Address: 148, Caldercliffe Road, Huddersfield, HD4 7RH

Application number: 2026/90571	
What is the application for?:	Installation of 1 BT Street Hub, incorporating 2 digital 75inch LCD advert scree
Address of the site or building:	Pavement o/s, Utilita, Ramsden Street, Huddersfield, HD1 2BQ
Postcode:	E1 8EE

Drg Status PLANNING				
Cell No. & Name HUD-09				
Site Name & Address Pavement o/s Utilita, Ramsden Street, Huddersfield, HD1 2BQ				
Drawing Title EXISTING AND PROPOSED ELEVATIONS				
Scale 1:50		Date 23/02/2026		
Drawn By PTM		Checked By ABH		
Drawing Number 003				Revision A

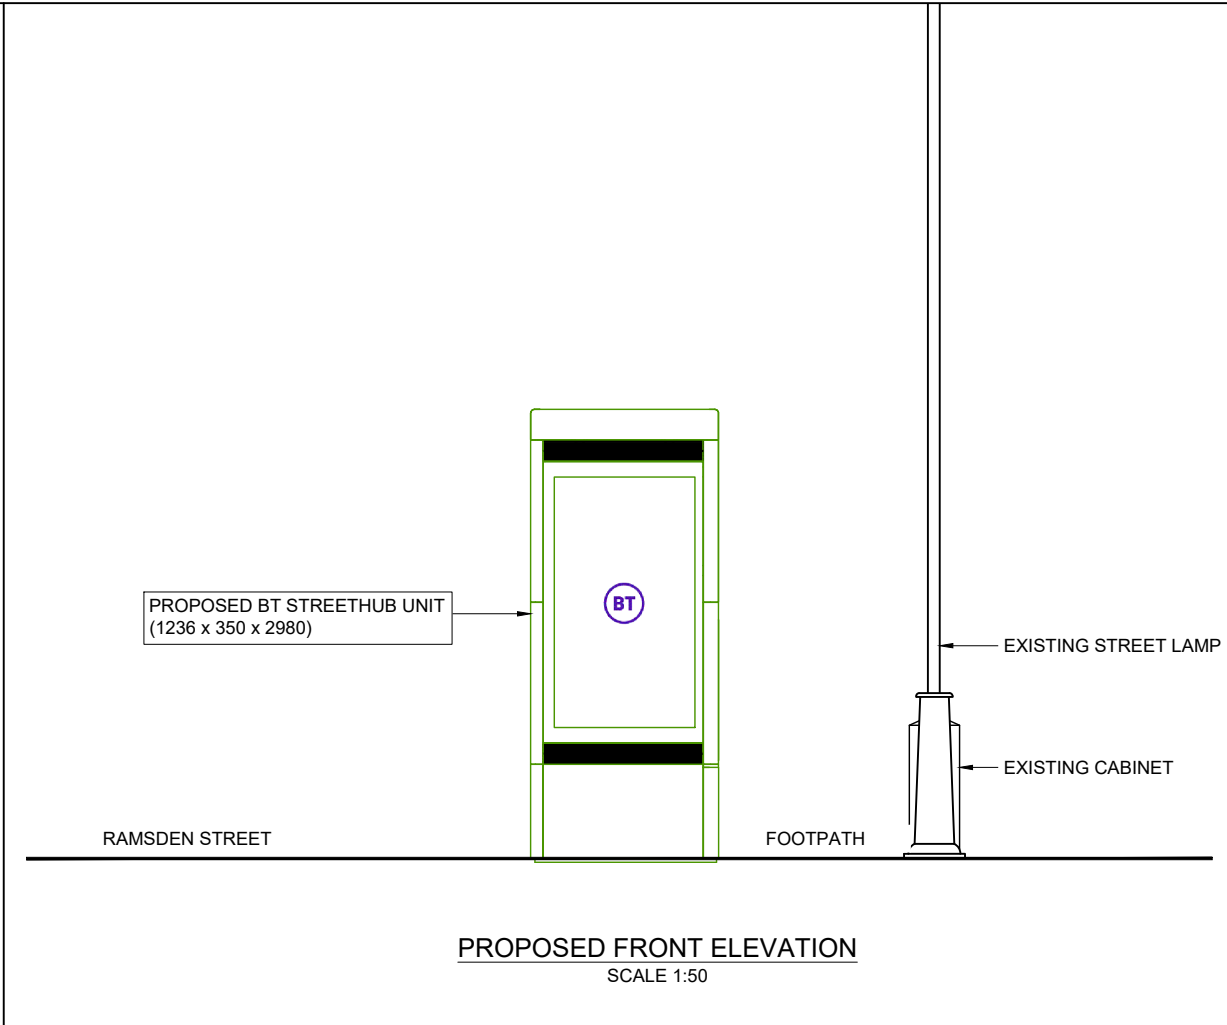
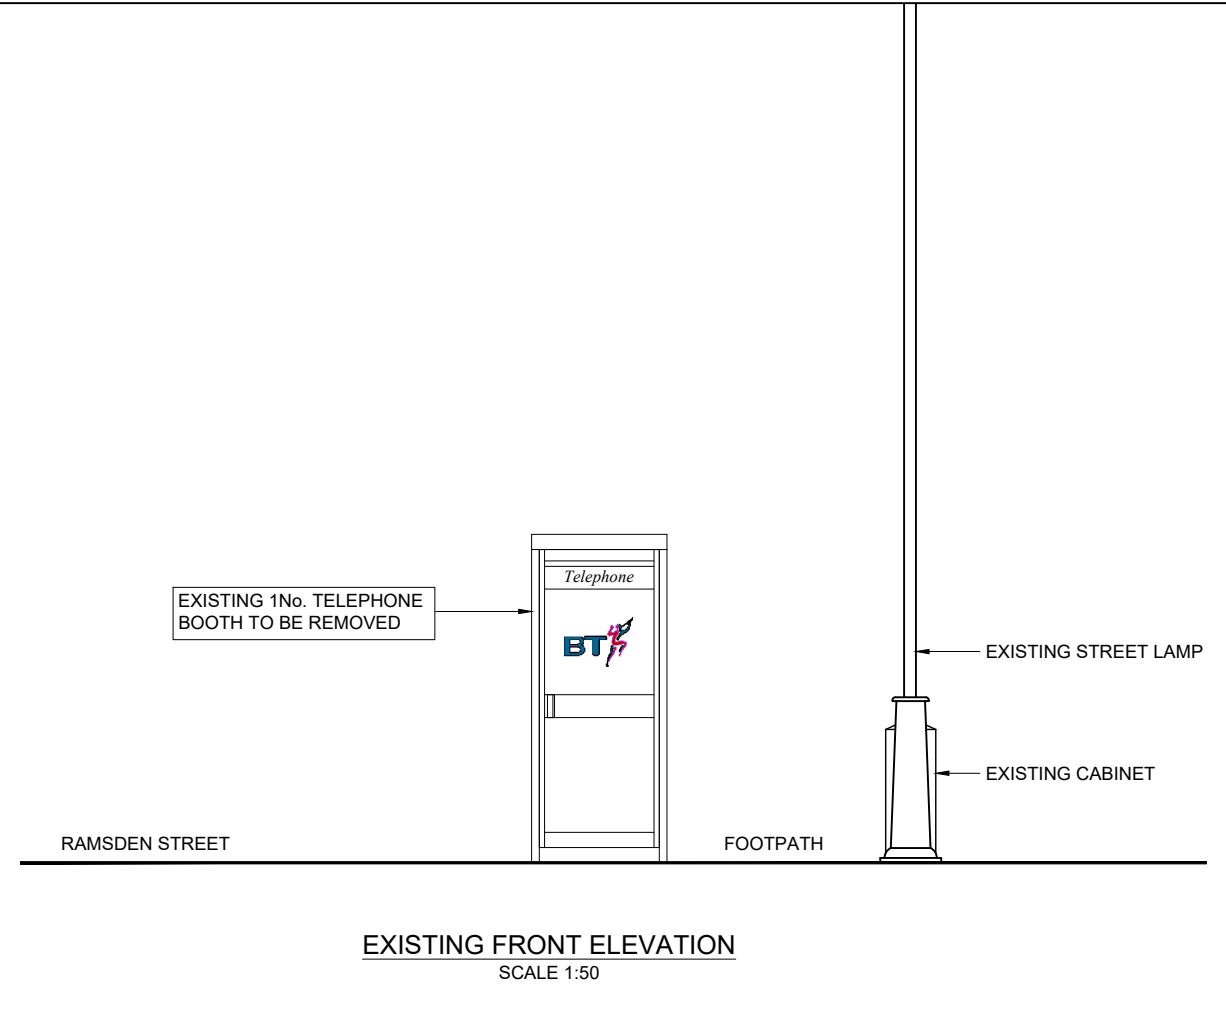
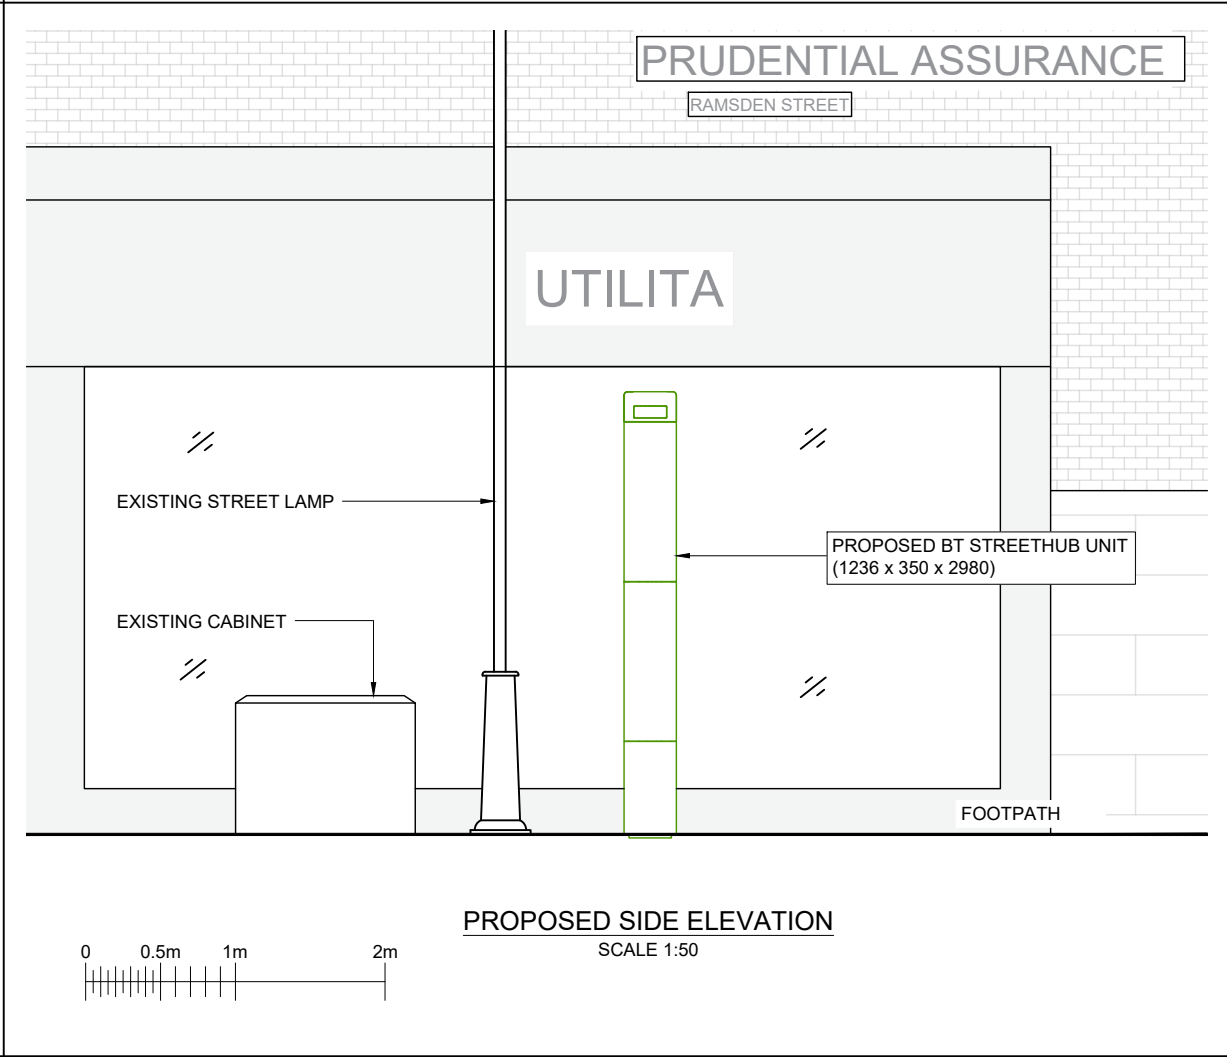
Type of comment: An objection	
Do you wish your comments to be published on the website anonymously?	No
Huddersfield civic society would like to object to this particular design of the newly proposed BT street hubs. We both understand and fully support the need to progress from the current outdated phone kiosks as well as providing the public with modern communication options such as emergency phone and public Wifi. However the need for 75 inch high advertisement screens creates unnecessary clutter within town centre conservation areas, particularly in Huddersfield where we are progressing to a more green and pleasant surrounding through the "Cultural Heart" build programme. Even outside the Conservation areas, they are unsightly, and allow for driver distraction. Surely its possible to provide both Wifi and emergency phones without these ugly additions.
